Online Comment

Application H16-0157-26
Location Between Mortimer & Beaulor The Raceground Spalding PE11 3AP
Proposal Erection of Bungalow - outline approval H16-1019-23

Name Diane Fairchild
Address Conservation Assistant (Tree Preservation) Planning & Development

SITE PLAN

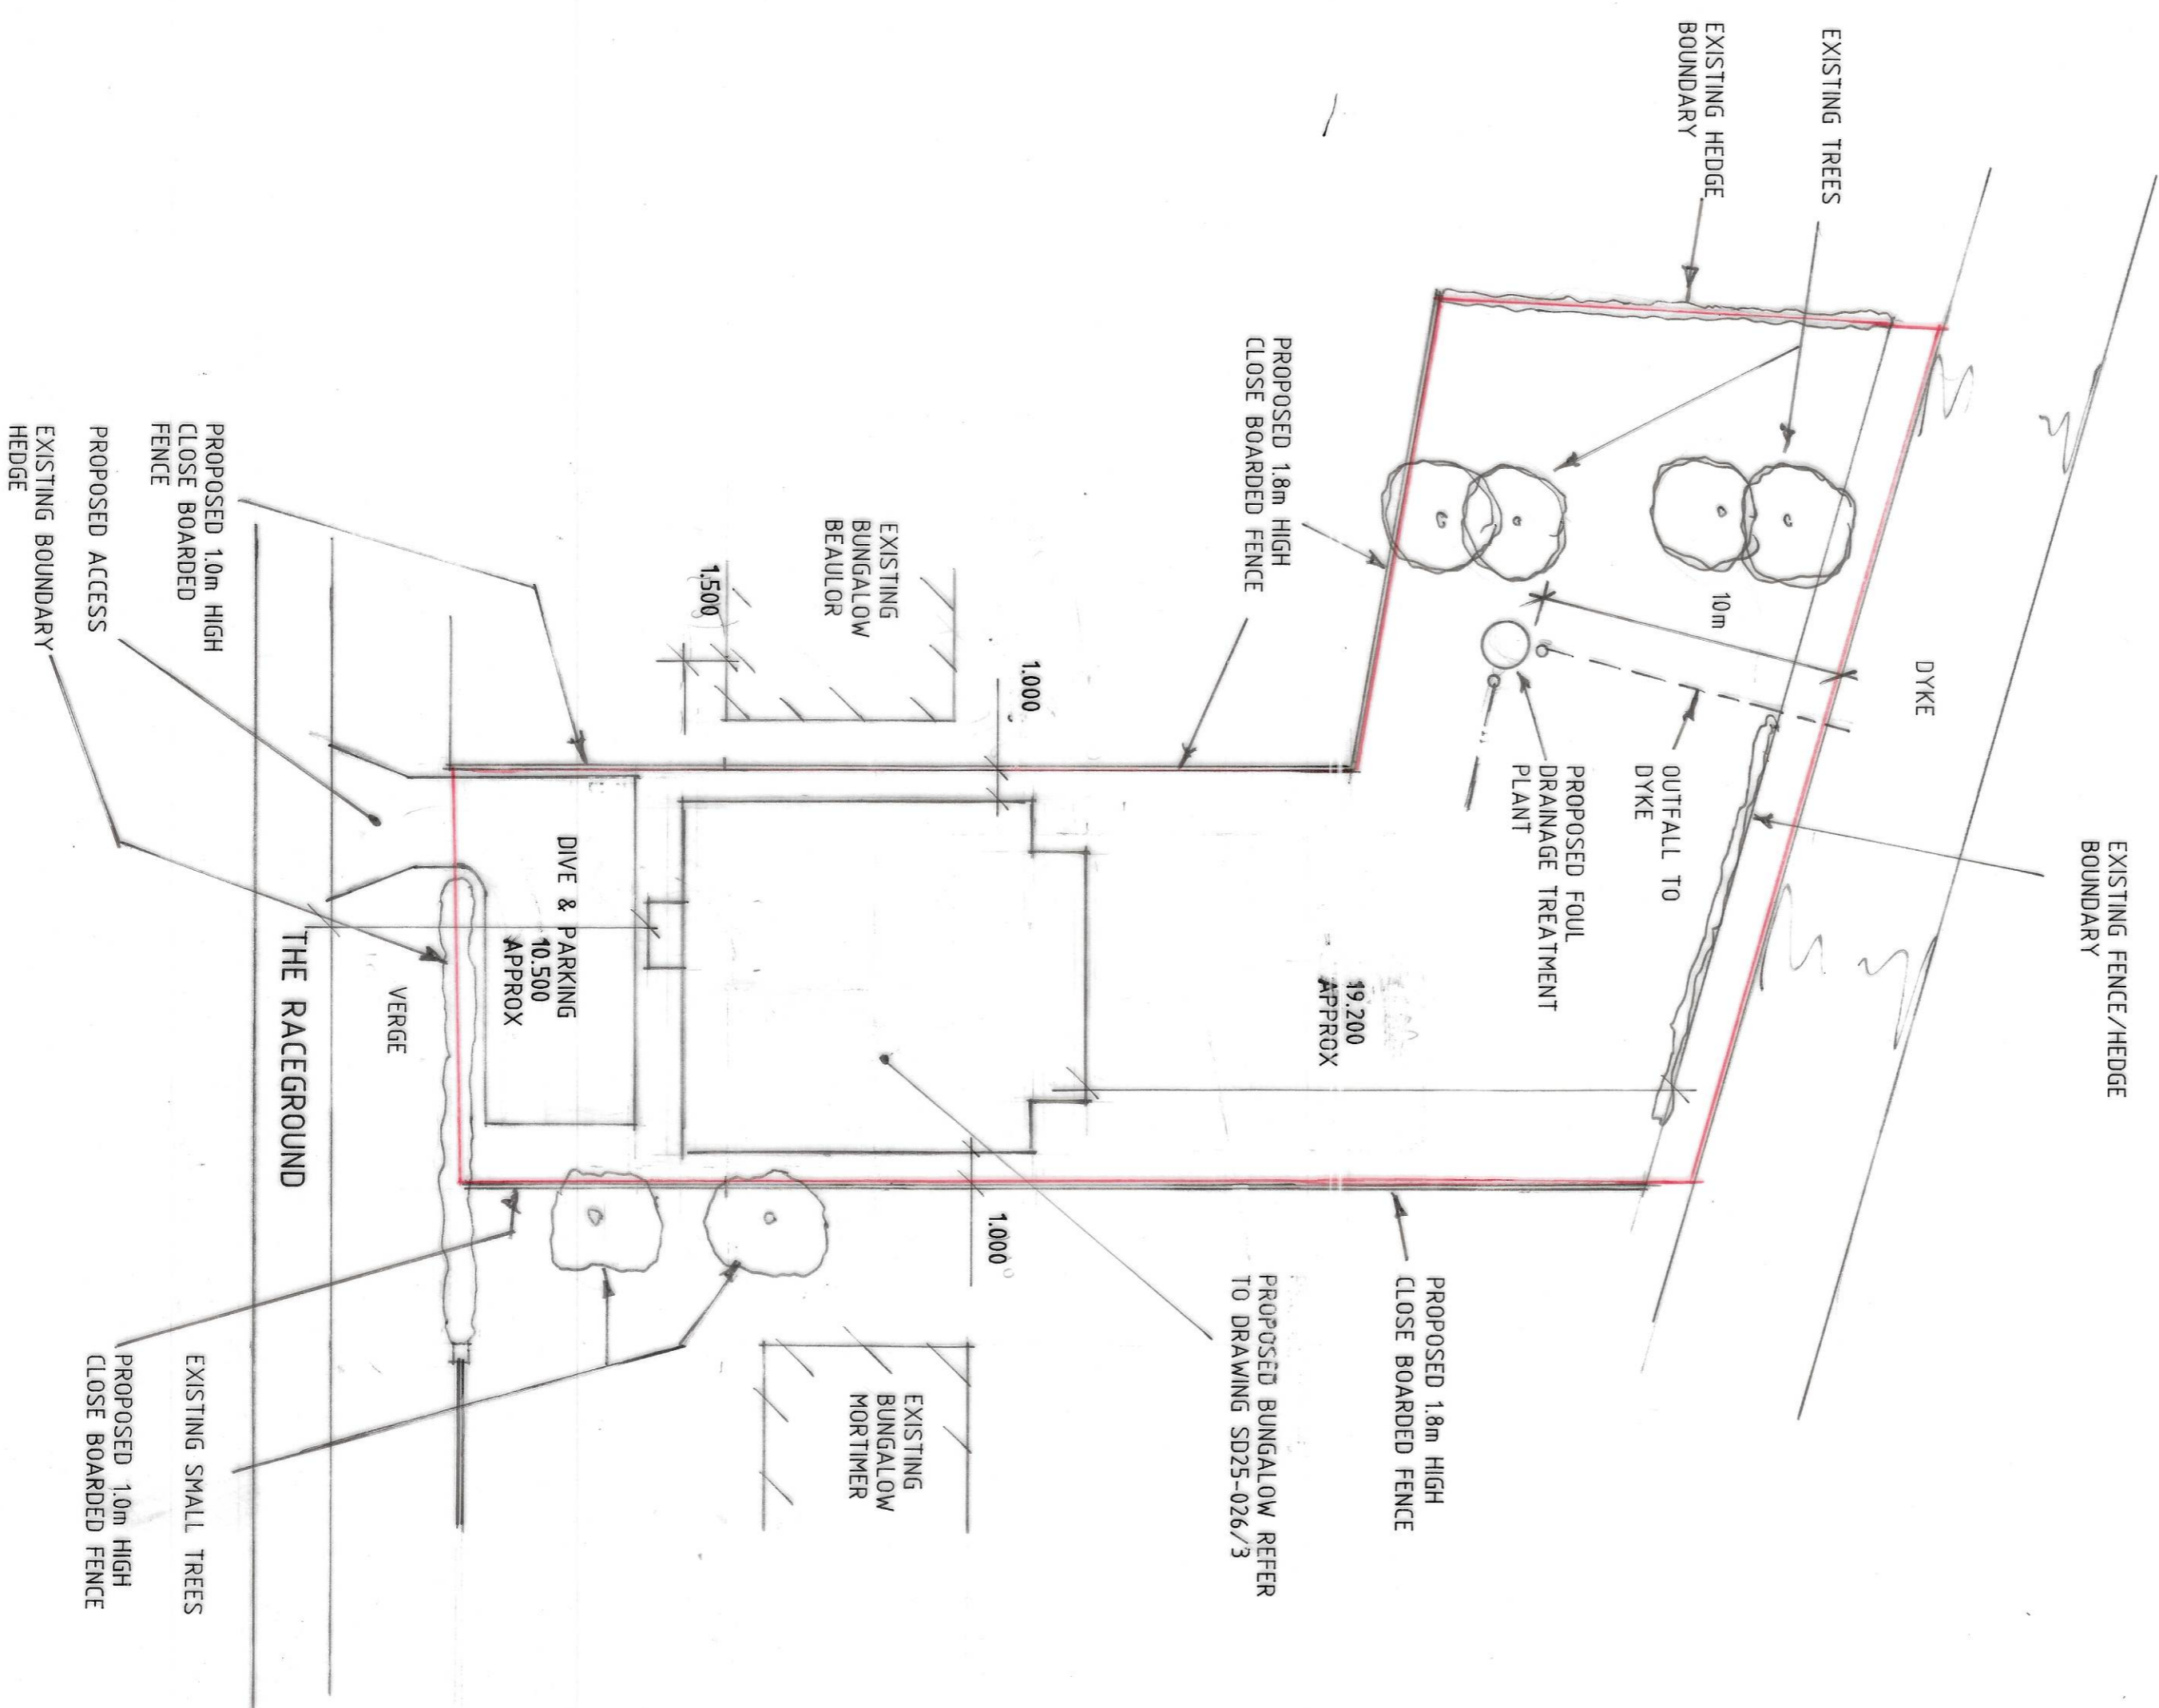
The frontage of the site is dominated by two mature apple trees whose trunks are within the curtilage of the property known as Mortimer, and which canopies encroach into the proposed site.

The trees are mature, such trees can bear fruit even when quite hollow, and add to the visual amenity of the street scene. The presence of these two trees should have been taken into account when plans for an adjacent property were drawn up. they seem to have been completely ignored.

The Root Protection Areas of both trees require calculation as in British Standard 5837:2012.

Ideally the proposed development should be re-designed so that AT LEAST the area covered by the Root protection Area of both trees is completely free of any encroachment by the proposed development. The further from the trees the footplate of the development is the better.

Root Protection Areas will need to be taken into account should it be proposed to construct any pathways or the like within them. 'No dig' methods of construction would be required.

Should development be allowed the trees will need fencing prior to any site clearance as in British Standard 5837:2012.
